Fire Marshal Division

Re: Abby & Bella's
24 E. Main St.
Coats, NC 27521

Application Number BCOM1904-0005

A100

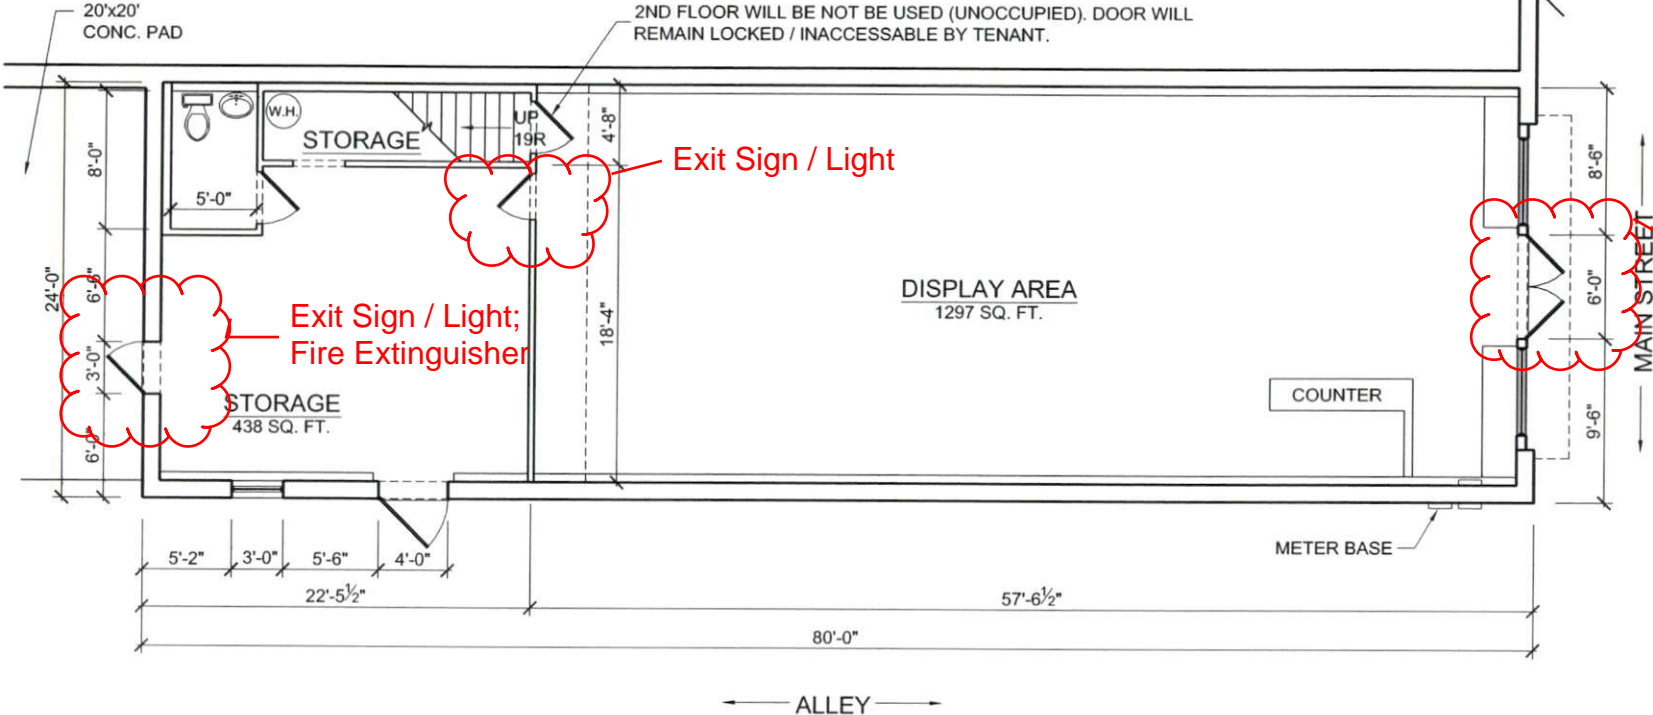
- **906.1 Fire Extinguishers**
 - Additionally Install (1) 2A10:BC fire extinguisher in the pool equipment room.
 - All Fire extinguisher shall be properly mounted and tagged by a fire extinguisher company.
 - Portable fire extinguishers shall be provided within a 30-foot (9144 mm) travel distance of commercial-type cooking equipment. Cooking equipment involving vegetable or animal oils and fats shall be protected by a Class K rated portable extinguisher.

- **1006.1 Means of Egress Illumination**
 - The means of egress illumination shall not be less than 1 foot-candle at the walking surface.

- Notes
 - Provide a Knox Box on the building if not present currently. This can be purchased by visiting knoxbox.com, clicking "BUY" in the top right corner of the page, and entering "Coats" as the fire department.
 - Emergency Exit Signs/Lights and Fire Extinguishers to be added at approved locations
 - A final fire inspection is required.
 - Schedule all fire inspections through the Fire Marshal's Office.
(910) 984-4003
